APPENDIX 7A

Engagement Summary Tables

Table 3 Northern Beaches Council (Pre-Lodgement Meeting)

1 DRIVEWAY SECTION
SCALE: 1:50@A1

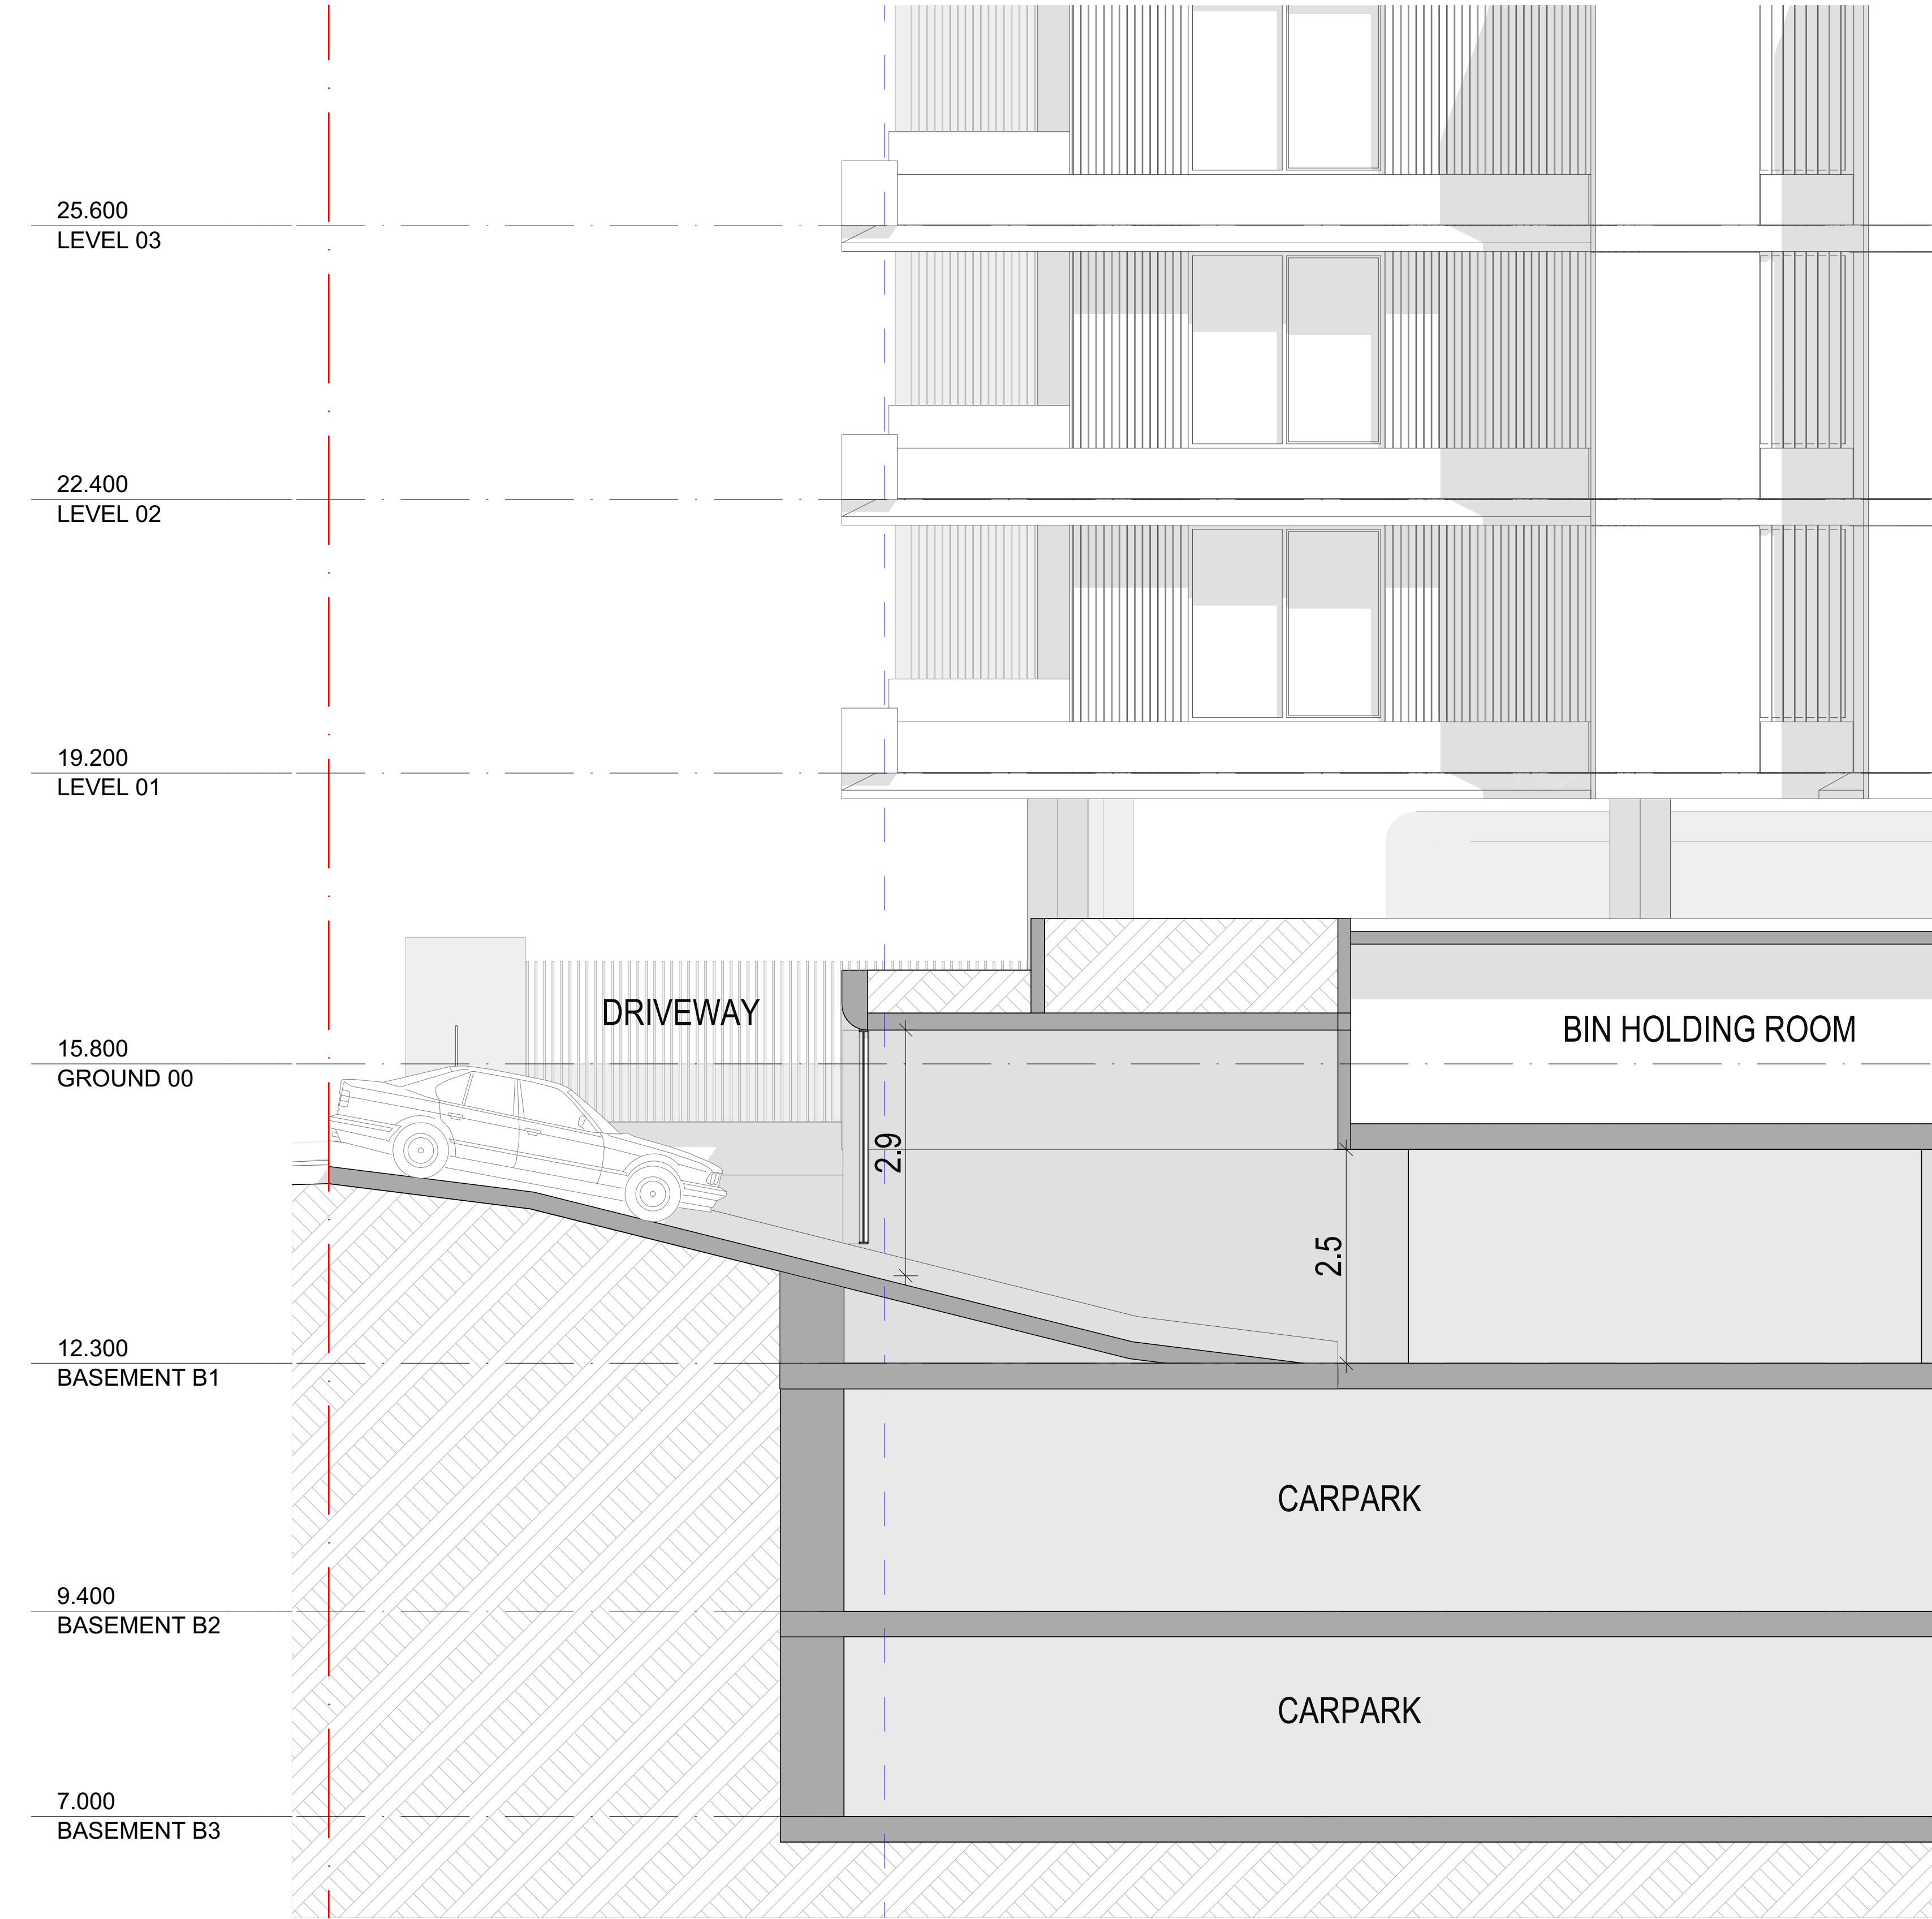
Traffic	- Generally, parking numbers, design and arrangement are supported. - Must demonstrate suitable clearance is provided to the loading bay on B1.	Noted. This has been confirmed in the Transport Impact Assessment at Appendix 31 of EIS
Landscaping Refer section 6.14 and Appendix 34 of EIS	- Lack of tree retention and planting in front and side setbacks should be expanded upon. - Arborist Report should consider impacts to neighbouring Tree 31 and 34.	The extent of tree removal is supported by an Arborist Report with significant compensatory planting proposed. Trees 31 and 34 are proposed for retention. TPZ and SPZs as well as other onsite management measures are proposed in the Arborist Report to ensure these trees are protected during construction and operation.
